13 October 2021

RE: AMENDMENT REPORT FOR SSD-10224, NEW PRIMARY SCHOOL AT EDMONDSON PARK

2 NORTH - WEST ELEVATION (FAULKNER WAY)
0005 1 : 250

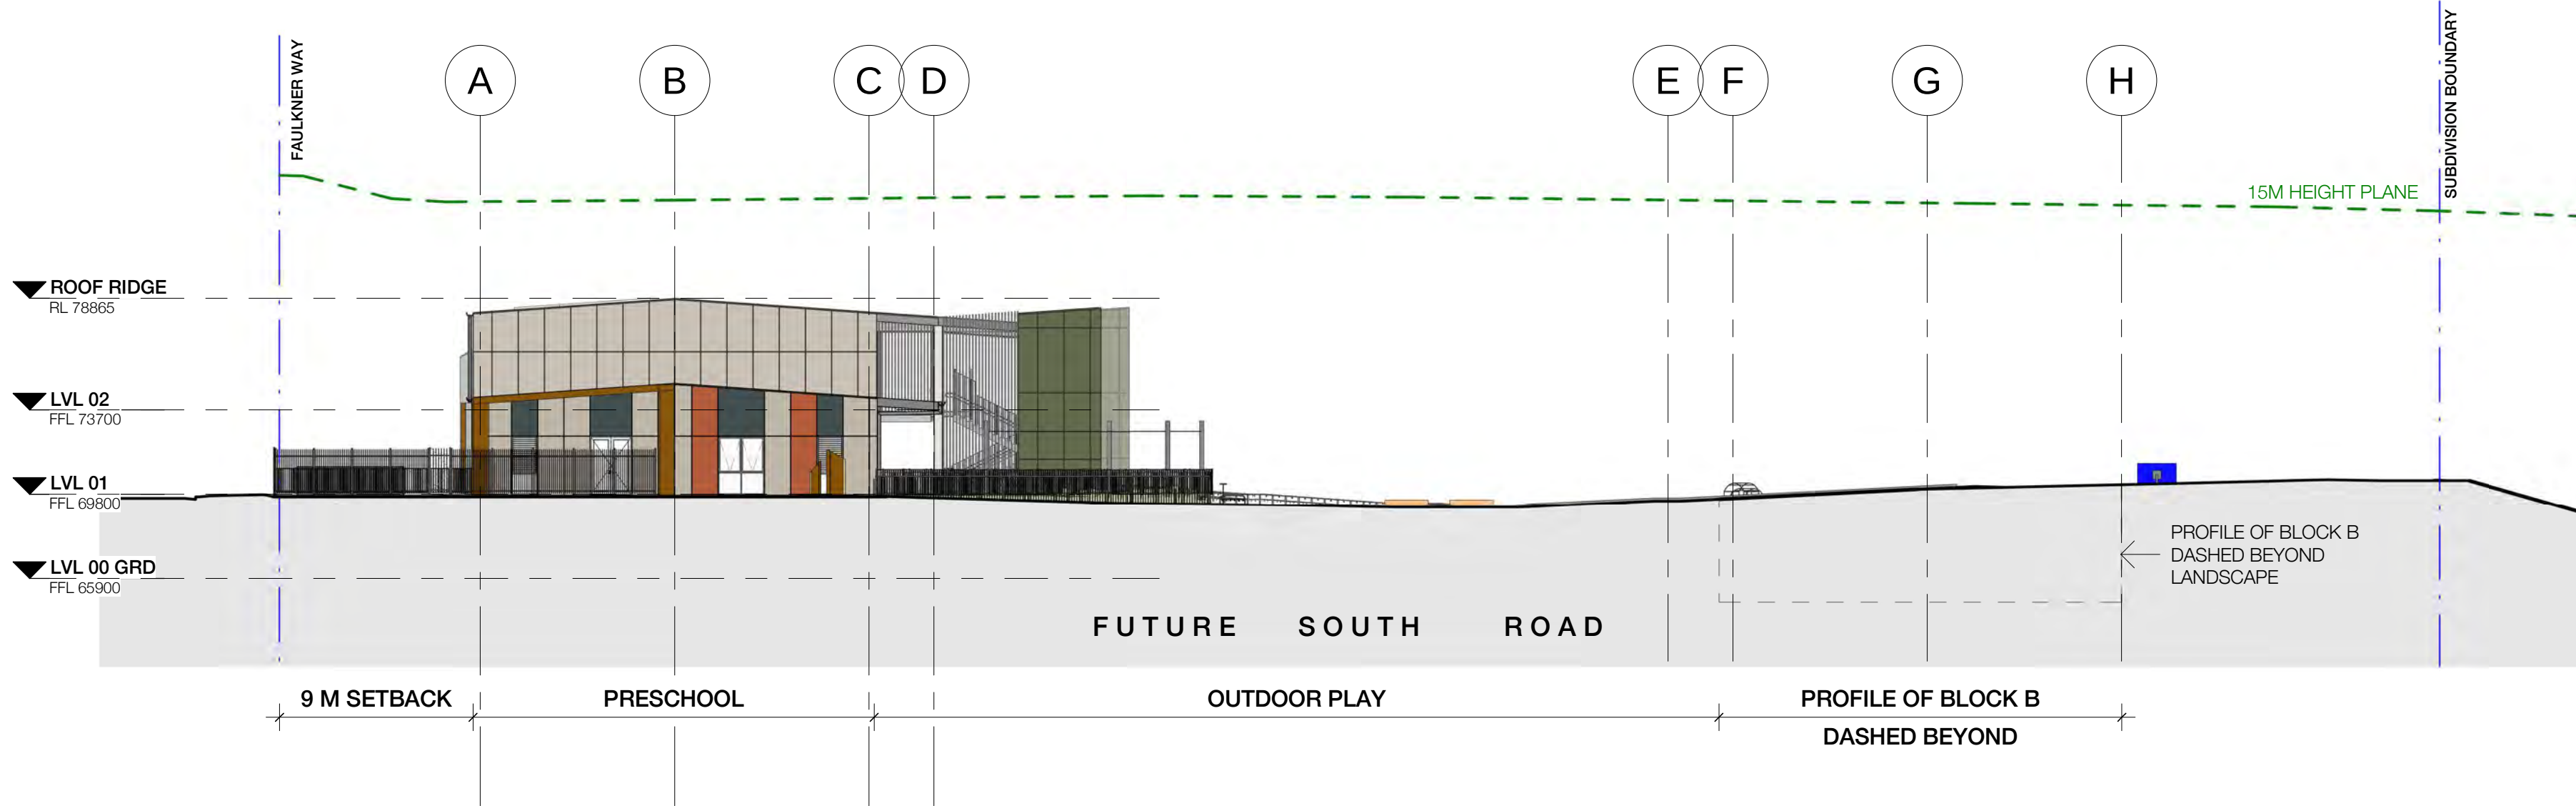
As shown on the Amended Architectural Plans in Appendix 2, SINSW seeks to amend the design of the sun-shades on the western elevation of the Faulkner Way building. The changes involve:

- Ground floor shading devices with horizontal blades only;
- Intermediate vertical blades removed from 2,140mm wide windows;
- Vertical blade elements removed from every second 800mm wide window, providing horizontal shading device only; and
- Blade depths consolidated to two proprietary dimensions – 427mm and 727mm.
